# SUNNICA ENERGY FARM

8.112 The Applicant's position on 'parcel by parcel' mitigation and residual effects

<b>Planning Inspectorate Scheme Reference</b>	EN010106
<b>Application Document Reference</b>	EN010106/APP/8.112
<b>Author</b>	Sunnica Energy Farm Project Team

<b>Version</b>	<b>Date</b>	<b>Status of Version</b>
Rev 00	13 March 2023	Deadline 8 Submission

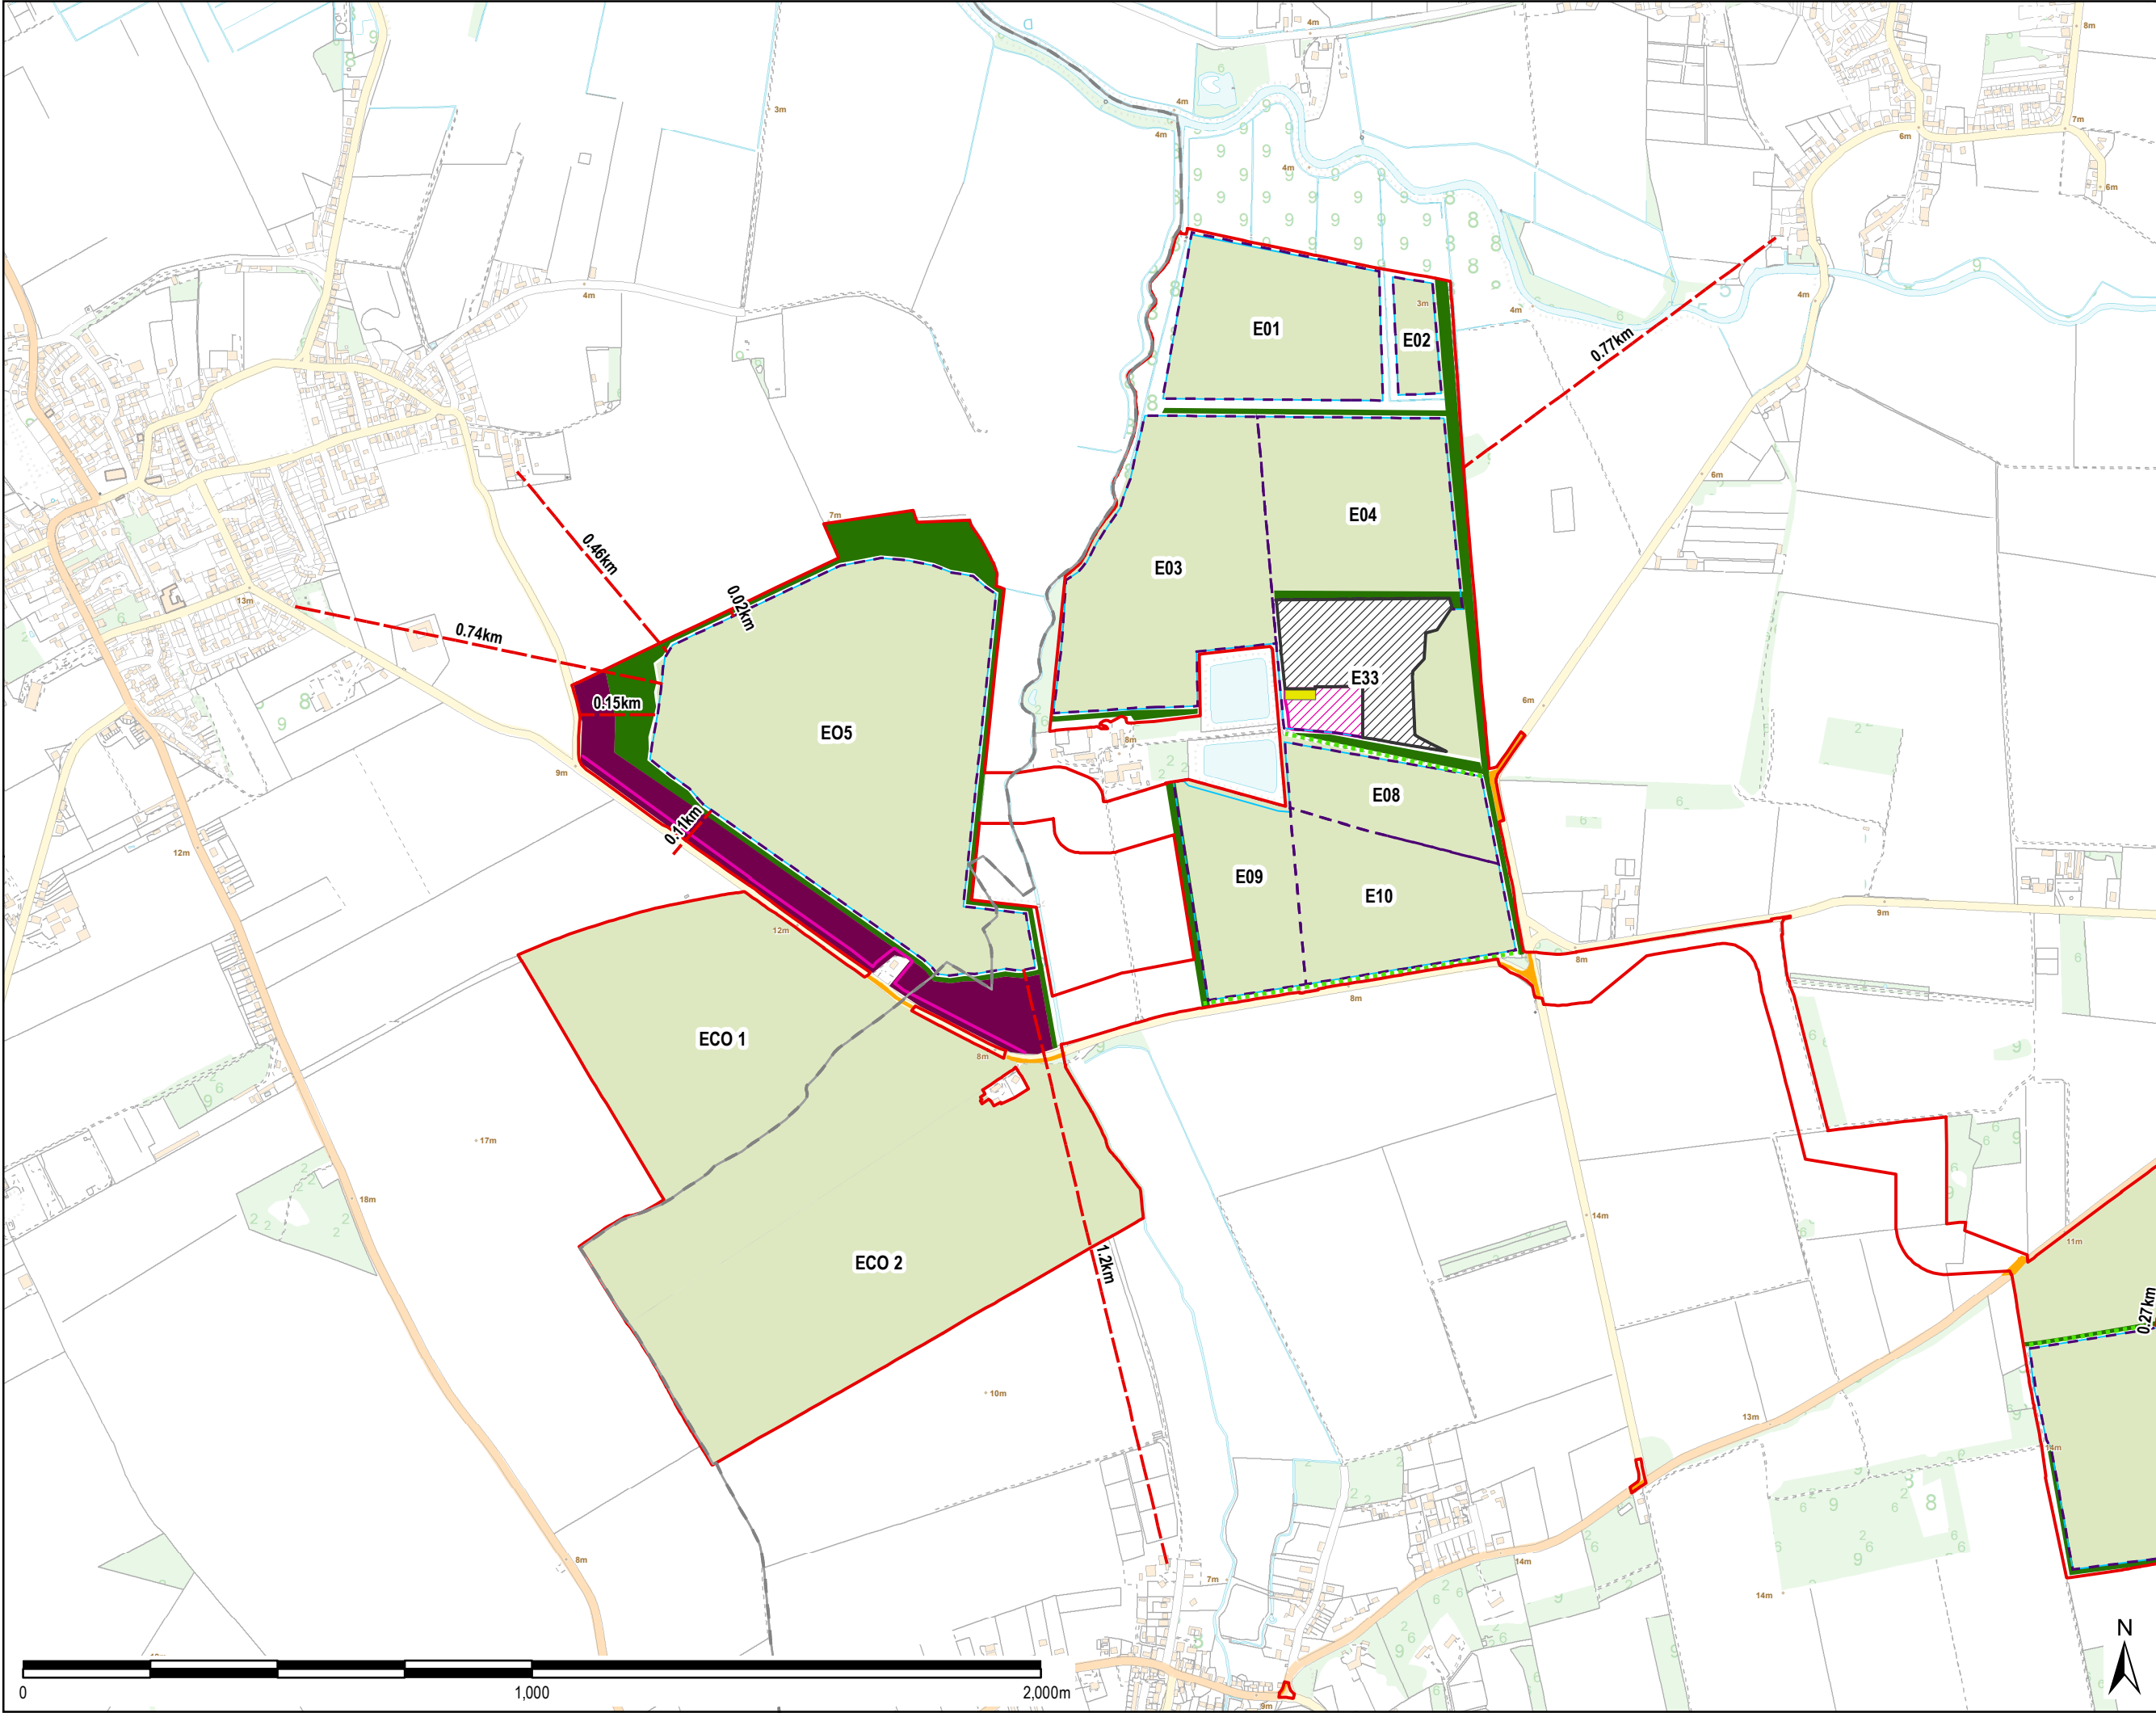
<b>ECO2</b>	– Native chalk grassland and stone curlew plots, will retain the open character of the land between Isleham and	- Existing PRow from Mortimers Lane within the eastern boundary of ECO2 will cause disturbance to Stone Curlew	-Provide a hedgerow between ECO2 and the existing PRow to define the route and replicate Mortimers Lane. A barrier to the public will be created	-	-Disturbance to Stone Curlew will remain in the short term, but as the hedge matures disturbance would be reduced over time, increasing the chances	An additional hedgerow has been added between ECO2 and the Lee Brook to deter access from the

<b>E04</b>	–Additional broadleaved woodland	-Potential for truncation of long- distance views	-Consider if, views from the residential	-	-	There are glimpsed views west from Ferry

<b>E33</b>	-Siting the primary construction compound, BESS and substation in E33 adjacent to reservoirs and Lee Farm, so that their massing and land uses are perceived in the context of existing infrastructure features and built structures in the landscape.	-BESS and substation will remain visible in the landscape from the edge of Isleham (VP3), River Lark (VP 01, 2A and 2B), Ferry Lane (VP2C) and the wider landscape to the south VP12A -Colour of external finishes for structures	- Plant a tree belt/woodland along the western side of E33 (Bess and substations). (see VP1, VP6, VP7) -Subject to archaeological constraints, there appear to be opportunities for a more	-	-The BESS and other solar infrastructure would remain visible and incongruent in the landscape initially including from the R Lark, Isleham, Ferry Lane and the wider landscape to the south, although the effects would be tempered by the tonal rendering of shades of structures.	The width of linear belts of trees and shrubs to the north (10m), east (15m) and south (15m) have been maximised within constraints to enclose and screen the substation and BESS [REP7-054].

<b>E08, E09 and E10</b>	Parcels E08, E09 and E10 are enclosed by new hedgerows, to screen views of the panels and reinforce existing hedgerow patterns. There is also a proposed area of chalk grassland within E09, above an archaeological mitigation area	-BESS and substation will remain visible in the landscape from VP12A, VP12B and wider landscape to the south.	-Photomontage suggests wider set back than Landscape Masterplan. (see VP12A) - Woodland north of E08 needs to be wider as views are far reaching towards BESS. -For E09 and E10 consider how the second hedge can be	- A second hedgerow is currently proposed along the southern edge of E09 and E10. Applicant to consider options for enhancing/increasing height of the existing hedgerow in this location	-Initially the BESS and substation will remain visible in the landscape from VP12A, VP12B and wider landscape to the south. -As the vegetation matures the effects would reduce particularly in the summertime although the planting would be	The woodland north of E08 has been reviewed and amended to more accurately reflect the arrangement of existing landscape features and expanded to 15m wide [REP7-054]. The proposed hedgerow north of Beck Road has been changed to a band of mixed shrubs, 10m

Ref.	Current proposals as detailed in OLEMP [REP5-014]	Residual effects	Further mitigation required [REP4-149] and LIR [REP1-024]	Applicants mitigation under discussion/or not yet shown on EnvM –[AS-324] and/or [AS-321]	Residual effects if the Council's mitigation is implemented in full	Applicant's response at Deadline 8
	Freckenham, to the west of Beck Road;		by the permanent predator fence		of successful Stone Curlew nesting.	existing bridleway as requested [REP7-054]. The observed use of these fields by Stone-curlew occurs against existing baseline levels of disturbance, however, the additional screening provided by new hedgerows in certain locations will further reduce potential disturbance as hedgerows mature.
<b>E01</b>	<p>- Panels are offset from the Fen woodland to the north and by 8m from the Lee Brook to the west.</p> <p>-New willow trees planting along the Lee Brook edge of E01 to provide additional riparian planting;</p>	<p>Small number of willow trees provided would not achieve the level of screening of the panels and BESS and other solar infrastructure required from the west (views from Isleham/Beck Road, and River Lark</p> <p>It is not clear whether the rush pasture is retained or proposed</p>	<p>Additional planting is required on western boundary to screen views from West Row and the River Lark and to make Lee Brook more legible in the landscape (views from Isleham and Beck Road).</p> <p>Clarification is required on the width of the buffer /setback form Woodland north of E01 and E02 (it was understood to be 40m [see REP3-019,p.104],</p>	<p>Applicant has committed to</p> <p>-Review screening along the west of the parcel to provide better screening of E33</p> <p>-Avoid any conflict with priority habitats where present</p>	<p>-Initial views of BESS from the River Lark but these would reduce as vegetation matures reducing the effects to an acceptable level.</p> <p>-Lee Brook would become more legible in the landscape, as the vegetation matures.</p>	<p>The offset from the Lee Brook is between 15m and 75m to retain its legibility in the landscape and to provide space for additional, dispersed riparian tree planting, which was added to the Environmental Masterplan at D7 [REP7-054]. The mitigation seeks a balance between visual screening and filtering of views and the open character of this</p>

Ref.	Current proposals as detailed in OLEMP [REP5-014]	Residual effects	Further mitigation required [REP4-149] and LIR [REP1-024]	Applicants mitigation under discussion/or not yet shown on EnvM –[AS-324] and/or [AS-321]	Residual effects if the Council's mitigation is implemented in full	Applicant's response at Deadline 8
	along the northern, southern and the eastern edges	of the Ark and St Andrews Church in Isleham.	properties on Ferry Lane to The Ark and St Andrew's Church in Isleham could be retained (see VP2C), with appropriate adaption of the proposed mitigation planting and siting of structures within E04.			Row through gaps in roadside vegetation. Linear belts of trees and shrubs are proposed along the eastern edge of Sunnica East Site A between 15m and 25m wide and will provide substantial screening of solar panel arrays. The substation and BESS will be screened from this location. The churches in Isleham are located on higher ground in the distant background relative to Ferry Road.

Ref.	Current proposals as detailed in OLEMP [REP5-014]	Residual effects	Further mitigation required [REP4-149] and LIR [REP1-024]	Applicants mitigation under discussion/or not yet shown on EnvM –[AS-324] and/or [AS-321]	Residual effects if the Council's mitigation is implemented in full	Applicant's response at Deadline 8
	-The tonal rendering of shades to integrate the permanent structures within the landscape will help to reduce their perceived overall mass.	to be green, light grey or white	robust woodland planting scheme east of E33, which would help to screen the BESS even during winter conditions. (see VPs 2A and 2B) -Or adjust the position of the infrastructure here to allow sufficient space for effective mitigation (LIR 10.170) -Environmental colour Assessment to be undertaken at detailed design stage to inform the external finishes of the structures		-As the vegetation matures the effects would reduce particularly in the summertime although the planting would be uncharacteristic in the open flat landscape.

Ref.	Current proposals as detailed in OLEMP [REP5-014]	Residual effects	Further mitigation required [REP4-149] and LIR [REP1-024]	Applicants mitigation under discussion/or not yet shown on EnvM –[AS-324] and/or [AS-321]	Residual effects if the Council's mitigation is implemented in full	Applicant's response at Deadline 8
			adapted to strengthen and enhance the existing hedge on the southern boundary		uncharacteristic in the open flat landscape.	wide, adjacent to the existing hedgerow, to widen and reinforce its habitat and screening function.
